DEVELOPMENT REVIEW BOARD APPLICATION

**RE: FINAL SIGN OFF OF EPC SITE PLAN
(PROPOSED 30 DWELLING DEVELOPMENT)
TRACTS 27A-1 AND 27A-2 OF TAYLOR RANCH, REDIVISION
OF TRACT 27A INTO TRACTS 27-A-1 AND 27-A-2 OF THE
PLAT OF TRACTS 27-A, S-1, S-2, AND S-3 TAYLOR RANCH,
SITUATED WITHIN SECTIONS 23, 25 AND 26 T11N R2E, BLOCK 0000,
LOCATED AT THE NORTHEASTERN CORNER OF THE
INTERSECTION OF MONTAÑO ROAD NW AND TAYLOR
RANCH ROAD NW (4701 MONTAÑO ROAD NW),
APPROXIMATELY 3.4 ACRES (E-11-Z AND E-12-Z)**

EPC CONDITIONS OF APPROVAL:

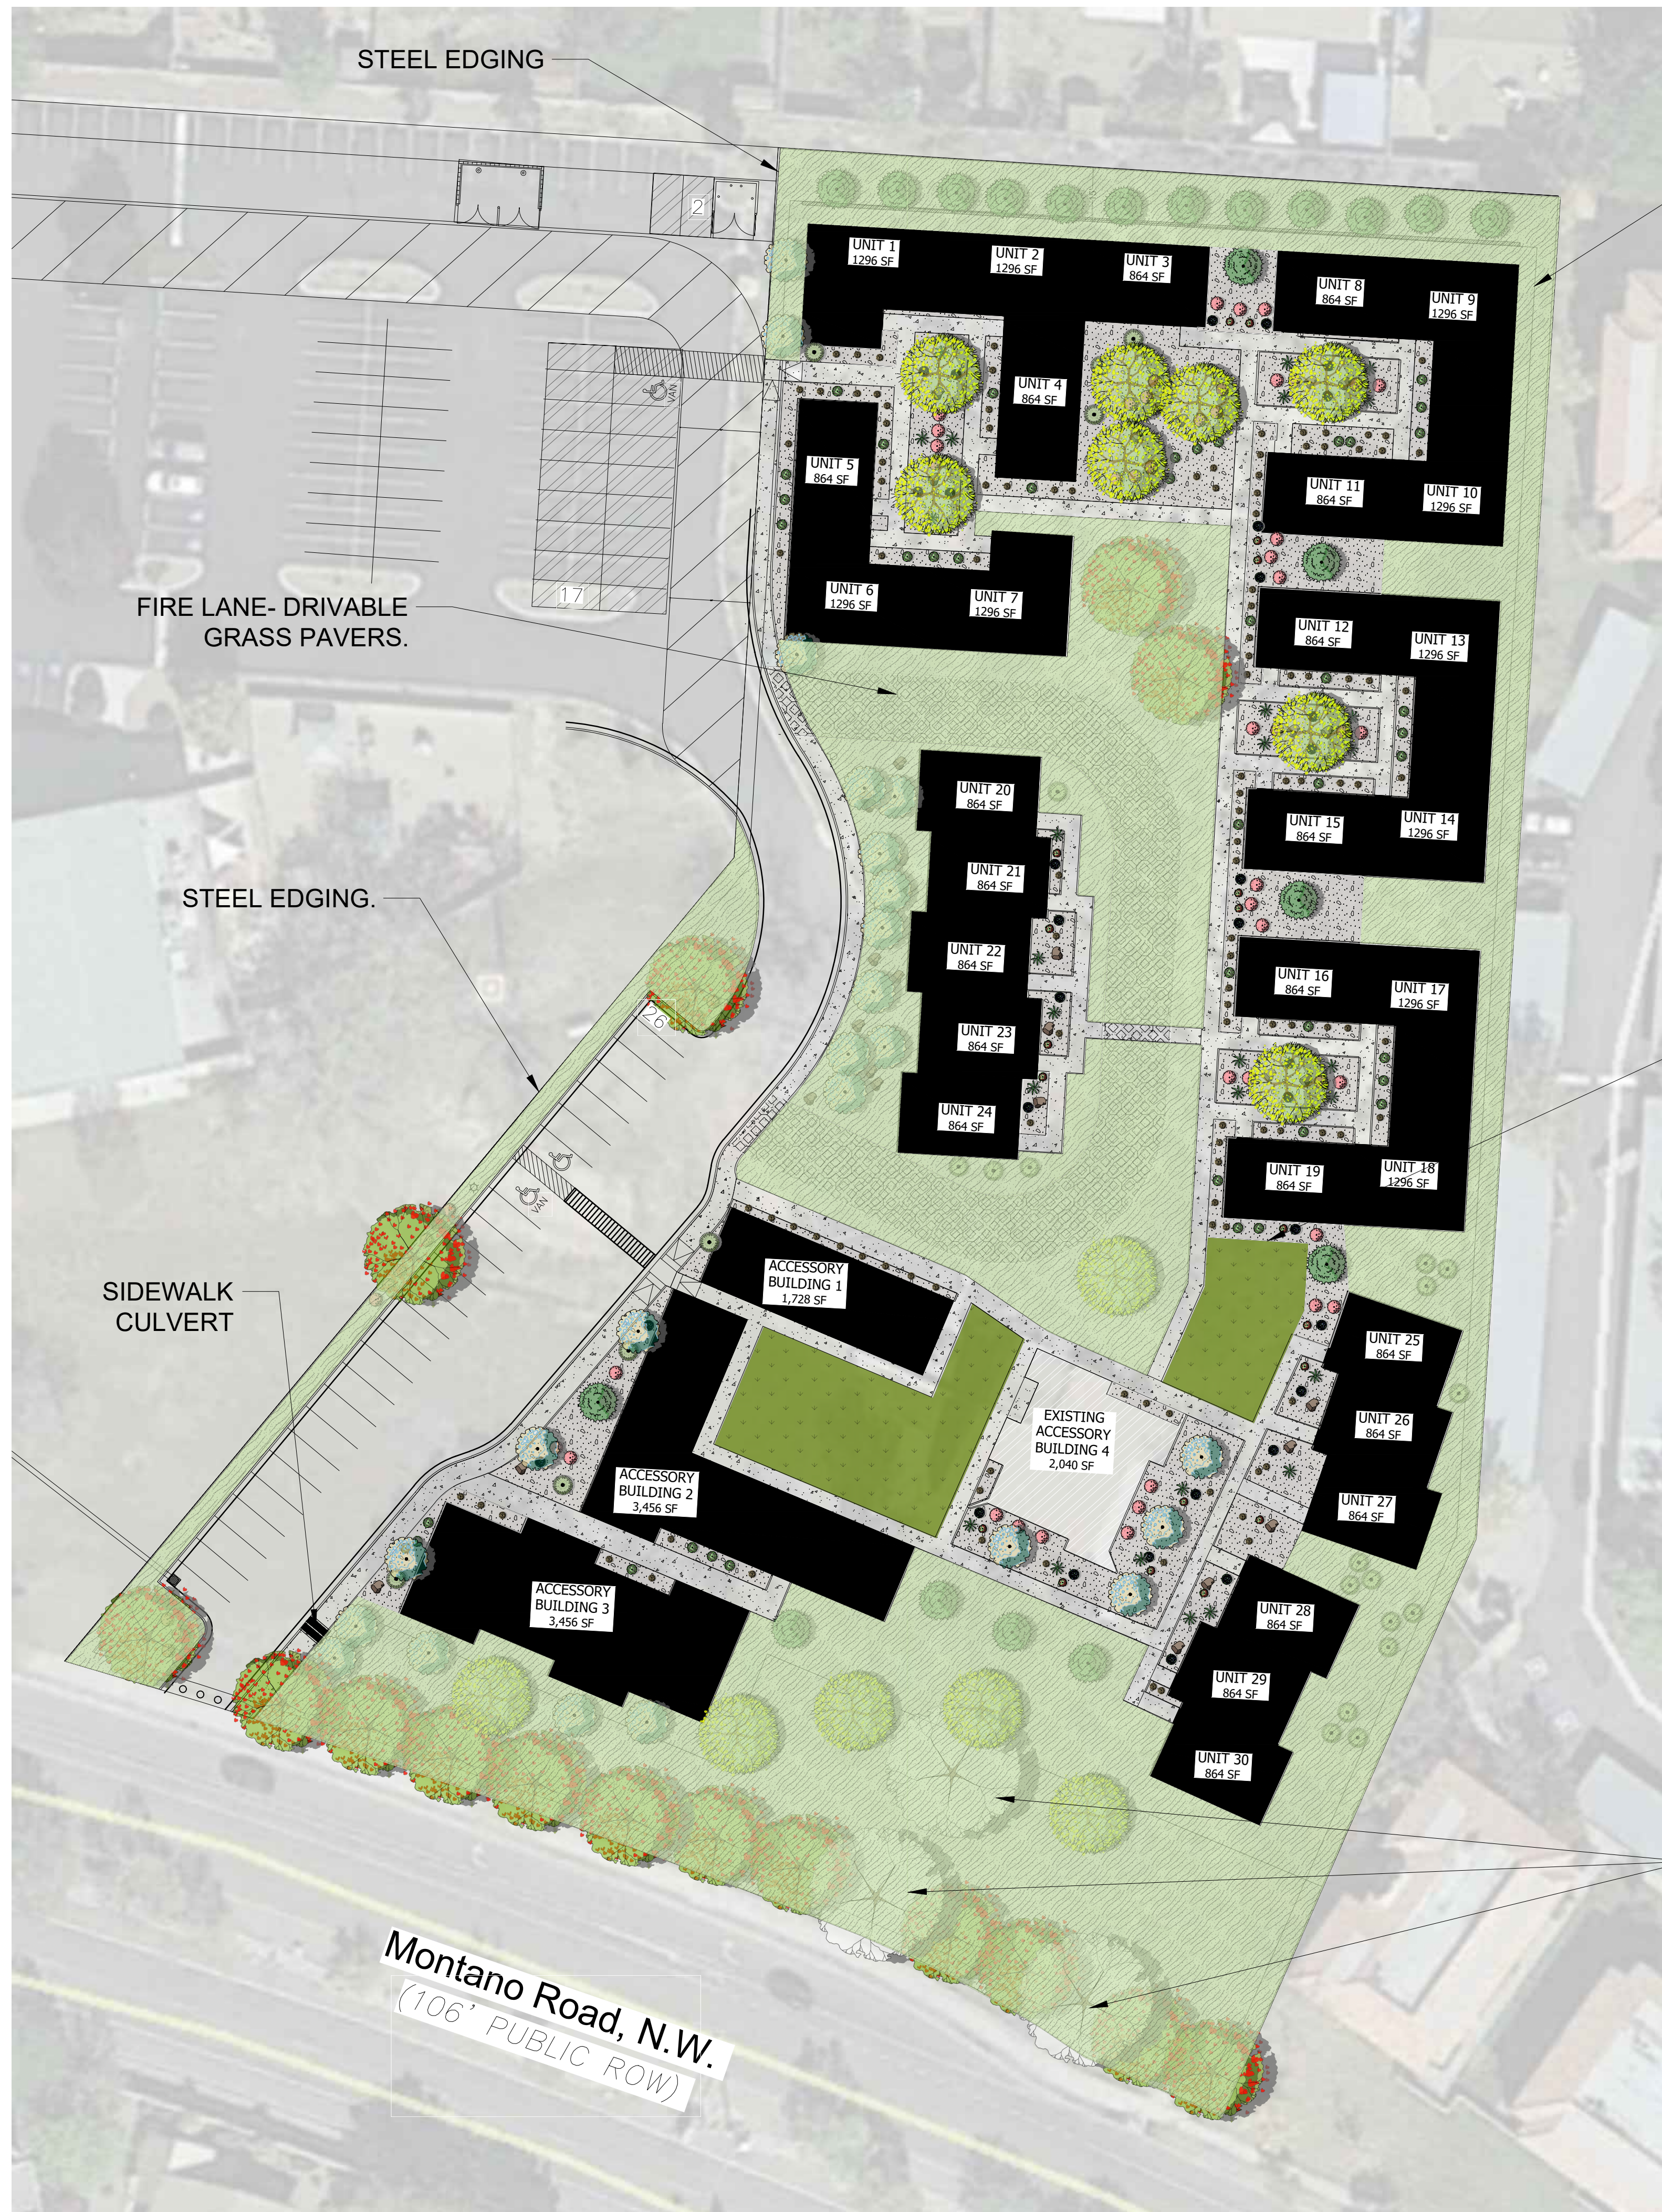
- A. The proposed, new retaining wall shall comply with the wall design requirements in IDO Section 14-16-5-7(E).
- B. A front-facing wall detail shall be provided.
- C. The refuse enclosure detail shall specify materials, colors, and finish.

- A. A light pole detail indicating height, color, and finish shall be provided [IDO Section 14-16- 5- 8-(D)(7)].
- B. Light pole locations shall be shown and a consistent symbol used.

- C. Fire Marshall approval of the site plan is required.
Received approval.
- D. Provide details for bollards at Montañó Road and landscape pavers. Coordinate with Fire Marshall.
Added to Detail Sheet C5.

Response: wall complies with IDO 14-16-5-7(E), front facing details added detail sheet C5, and refuse enclosure details for color added.

Response: Light pole detail with height, color and finish added to detail sheet C5 and the symbol used is consistent throughout.

UNIT NO. 6 - TYPICAL

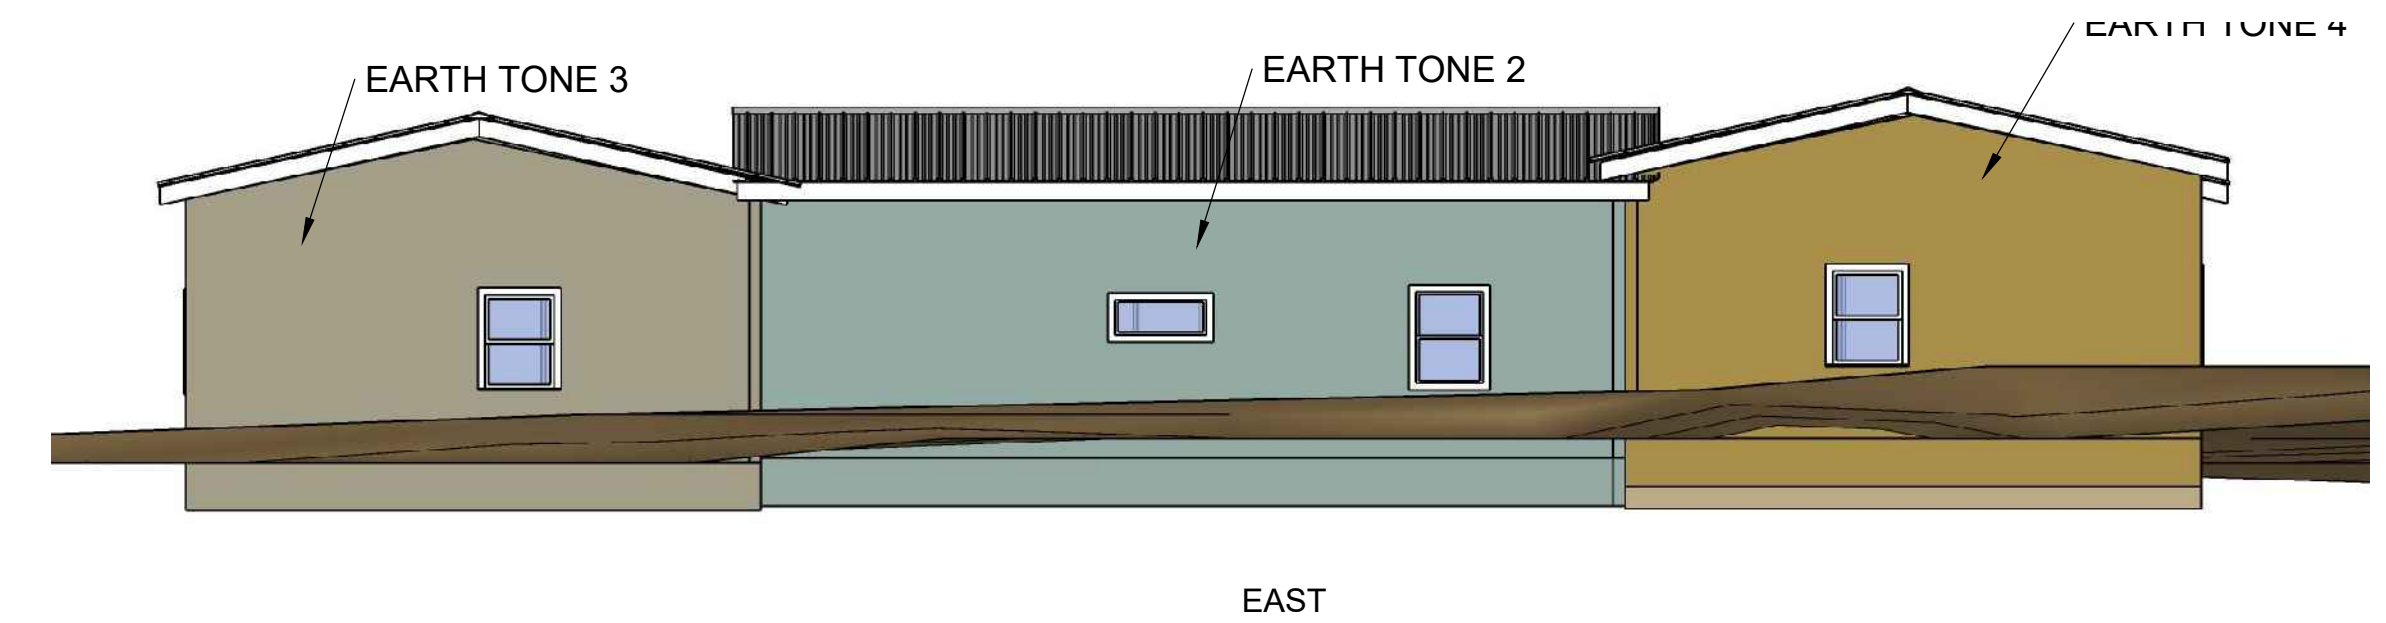
- A. Elevations for the accessory buildings (1, 2, and 3) shall be provided and provide necessary details such as dimensions, colors, and finishes.
- B. The materials and finishes of the buildings, roofing, framing, and trim, shall be specified.
- C. The word "typical" shall be added to the labels for Unit 6 and Unit 9.

Response: elevations for the accessory buildings 1, 2 and 3 added to the elevation sheets, and the materials and finishes of the buildings, roofing, framing, and trim, are specified. "Typical" added to the labels for Unit 6 and Unit 9.
